Subject: VA-20-00007, Fuhrer Setback Variance
SR 906 MP 1.78 right

TO: All Staff
FROM: Public Works Planning Review Team
DATE: September 15, 2020
SUBJECT: VA-20-00007 Fuhrer

SITE PLAN 1/2" = 6'

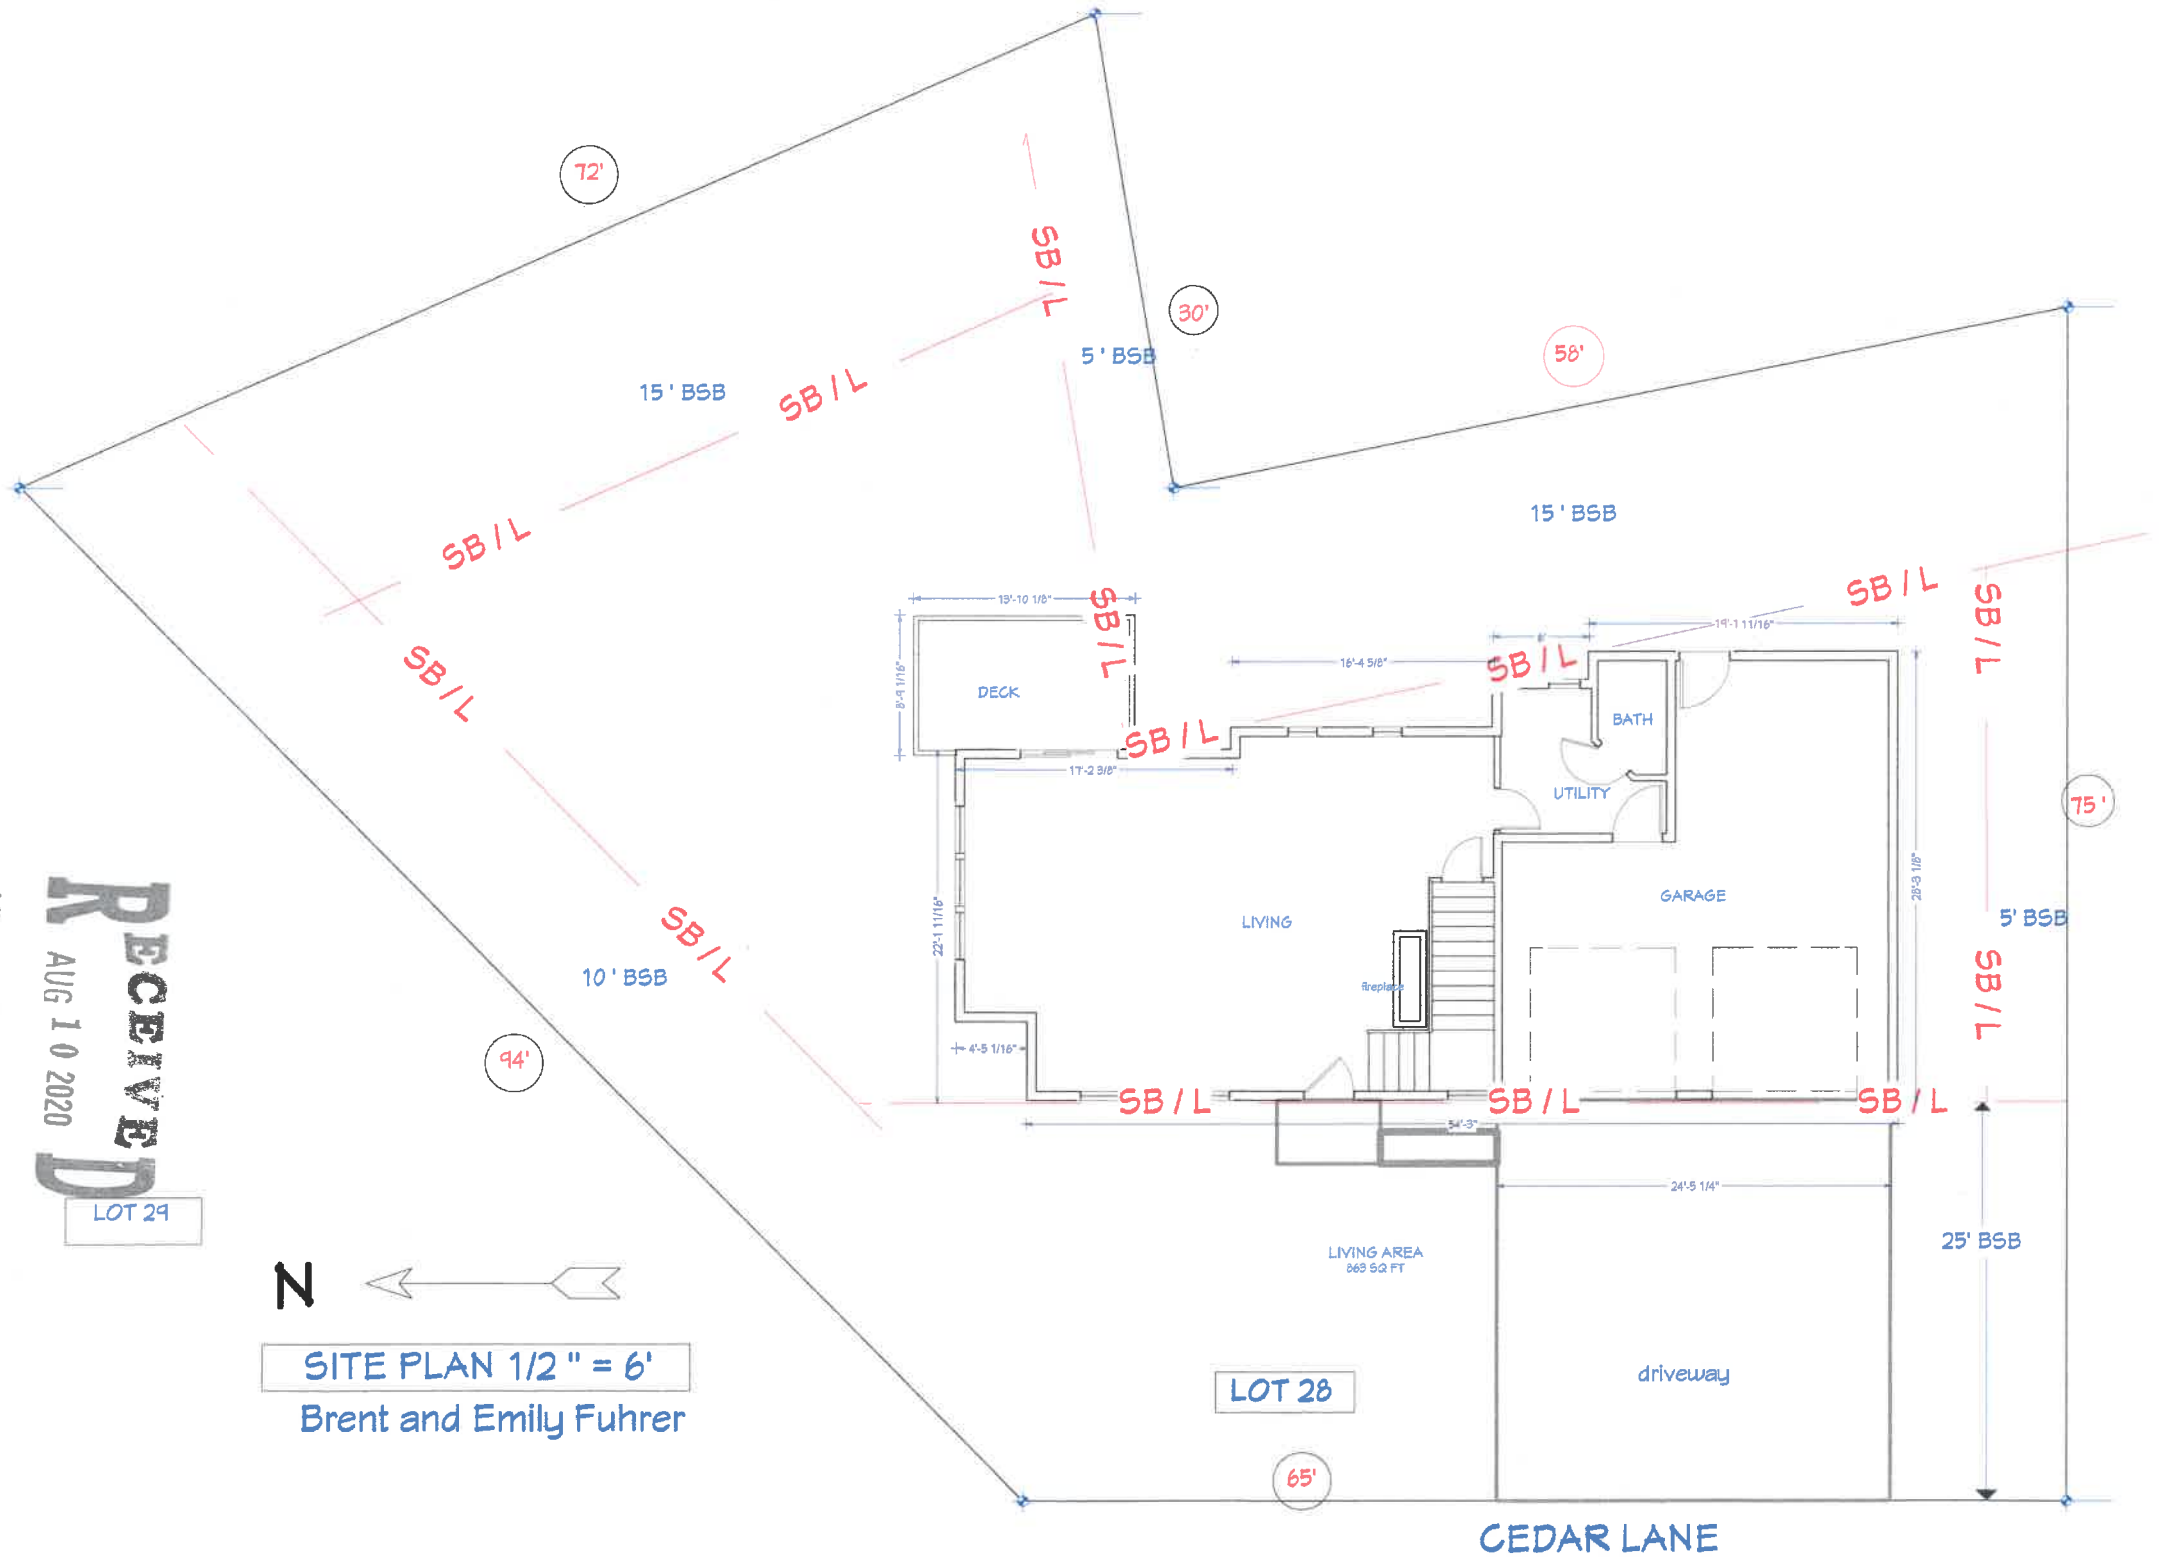
- The subject property is adjacent to the State Route 906 (SR 906). SR 906 is a managed access class 4 highway with a posted speed limit of 35 miles per hour. Direct access to the highway is prohibited.
- The site plan does not identify an area for snow storage. Any snow accumulated on the property shall not be moved onto WSDOT right-of-way. We encourage the proponent to not underestimate the potential for large volumes of snow and designate a snow storage area on the property.
